OXFORDSHIRE COUNTY COUNCIL'S RESPONSE TO CONSULTATION ON THE FOLLOWING DEVELOPMENT PROPOSAL

Application no: 23/01586/REM

Proposal: Reserved Matters Application pursuant to Outline planning permission 14/02121/OUT for the erection of 123 dwellings (including 37 affordable dwellings), parking, landscaping and other associated infrastructure including the part discharge of conditions 12 (Building for Life 12), 13 (future climate risks statement), 14 (noise assessment), 16 (means of vehicular access), 17 (means of pedestrian/cycle links), 18 (Travel Plan), 19 (detailed surface water drainage scheme), 20 (carbon minimisation), 24 (pollution prevention scheme for surface water), 25 (biodiversity), 26 (hedges), 27 (Arboricultural Method Statement), 29 (Landscape and Habitat Management Plan), 30 (Construction Method Statement), 31 (Soil Resources Plan), 34 (Foul Drainage Strategy), 36 (Water Neutrality Strategy) and 37 (Site Waste Management Plan) at Phase 2A

Location: Proposed Himley Village North West Bicester, Middleton Stoney Road, Bicester

HIMLEY VILLAGE, BICESTER - PHASE 2A - BOUNDARY TREATMENTS PLAN

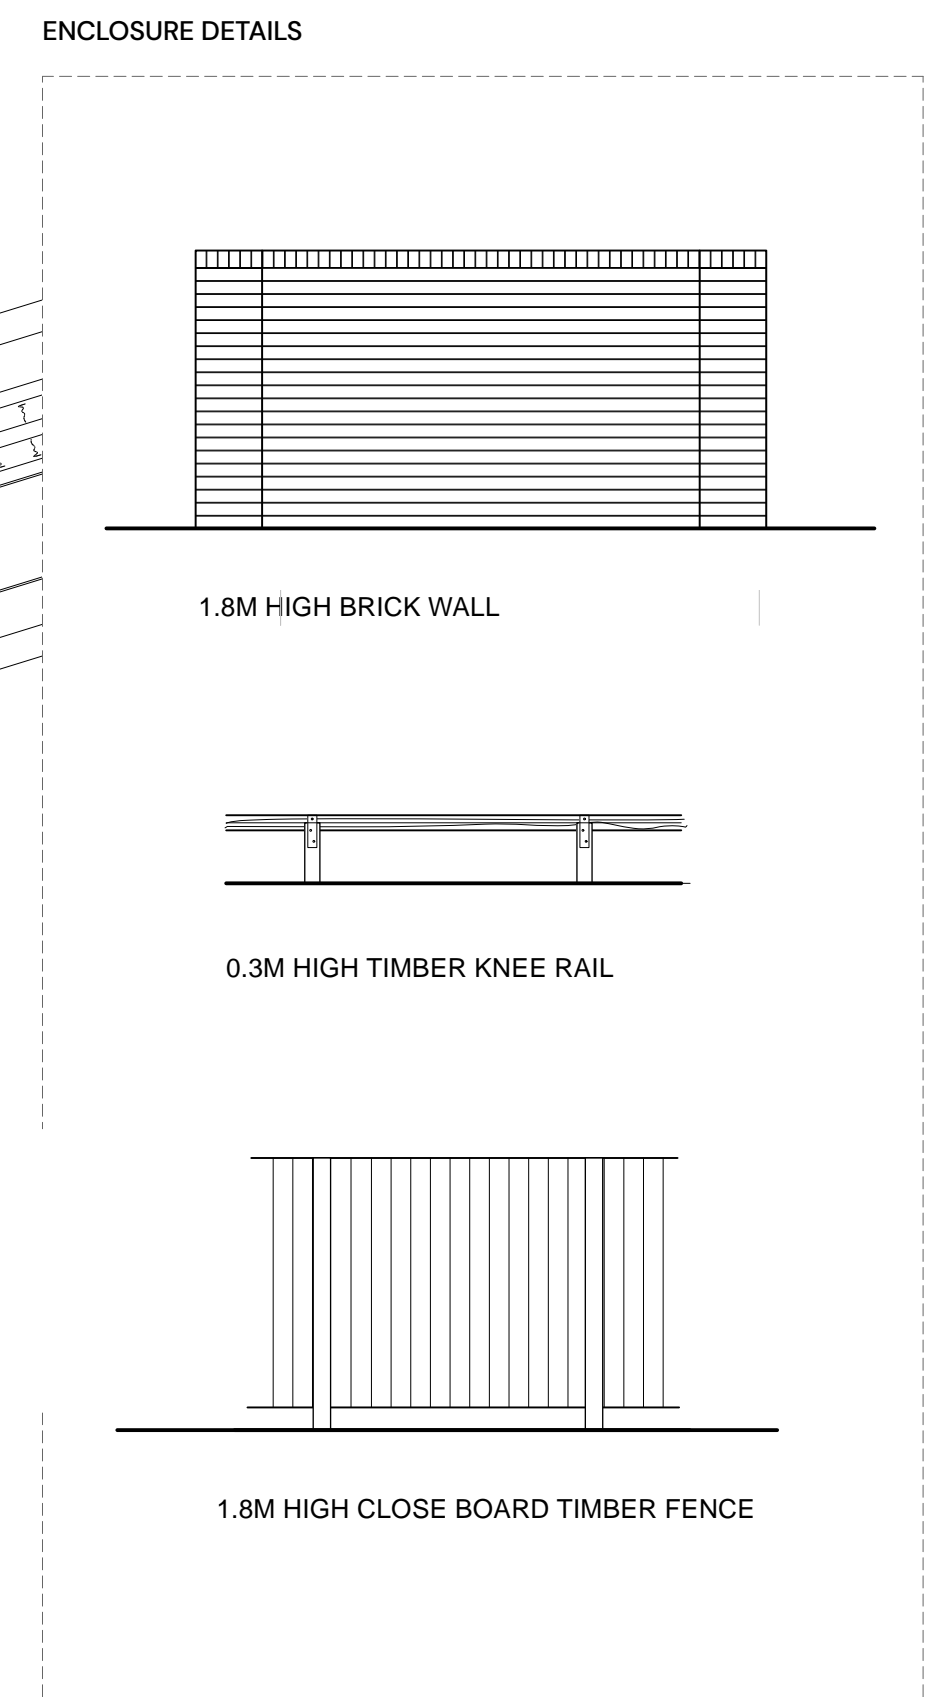
Plots 119 and 120: the ends of these driveways are close to a 3m walking and cycling route that will connect through to the adjacent parcel. The ends of the driveways are proposed to be fenced off. There should be a walking route through so that the residents can access the path directly.

Adjacent to apartment block 96-101: the above mentioned ped/cycle route needs to connect through to the tertiary street with a path of the same width. It should connect through to the strategic spine road too – as shown it narrows to 2m and is bounded on one side by a high wall (care home boundary is unknown), with no lighting, so will be a very unattractive route, with possible personal safety issues.

Adjacent to plot 20, the route through to the adjacent mixed use area should be a cycle connection.
